Our ref: S13/95

28 May 2014

RE: Banksmeadow Waste Transfer Terminal (SSD 5855)

The Council has received notification from the Department regarding the above mentioned application for the construction and operation of a waste transfer terminal and associated rail infrastructure at 14 Beauchamp Road and 34-36 McPherson Street, Banksmeadow. Council has reviewed the Environmental Impact Statement (EIS) dated April 2014 prepared by Hyder Consulting Pty Limited.

ROOF PLAN
SCALE 1:100 @ A1

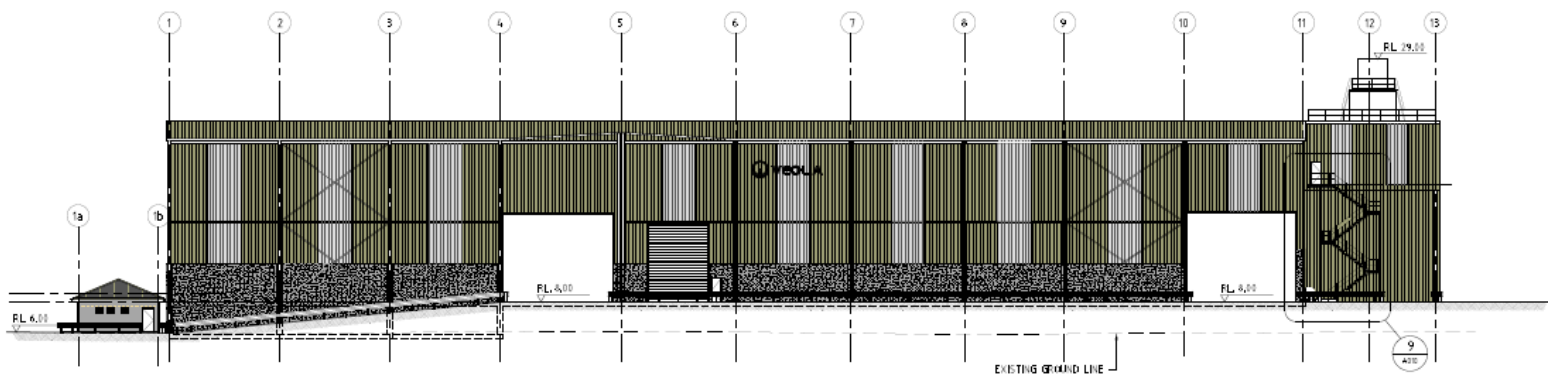
No building heights and RLs have been provided on the Architectural Roof Plan & Elevations (Drawing No: A004 Issue A) prepared by Hyder dated 21 February 2014. Furthermore, the natural ground level should be clearly indicated on the architectural plan and elevations.

Note: As the ventilation stack exceeds 15.24m, the application should be referred to Sydney Airport Corporation Limited (SACL) for comment.
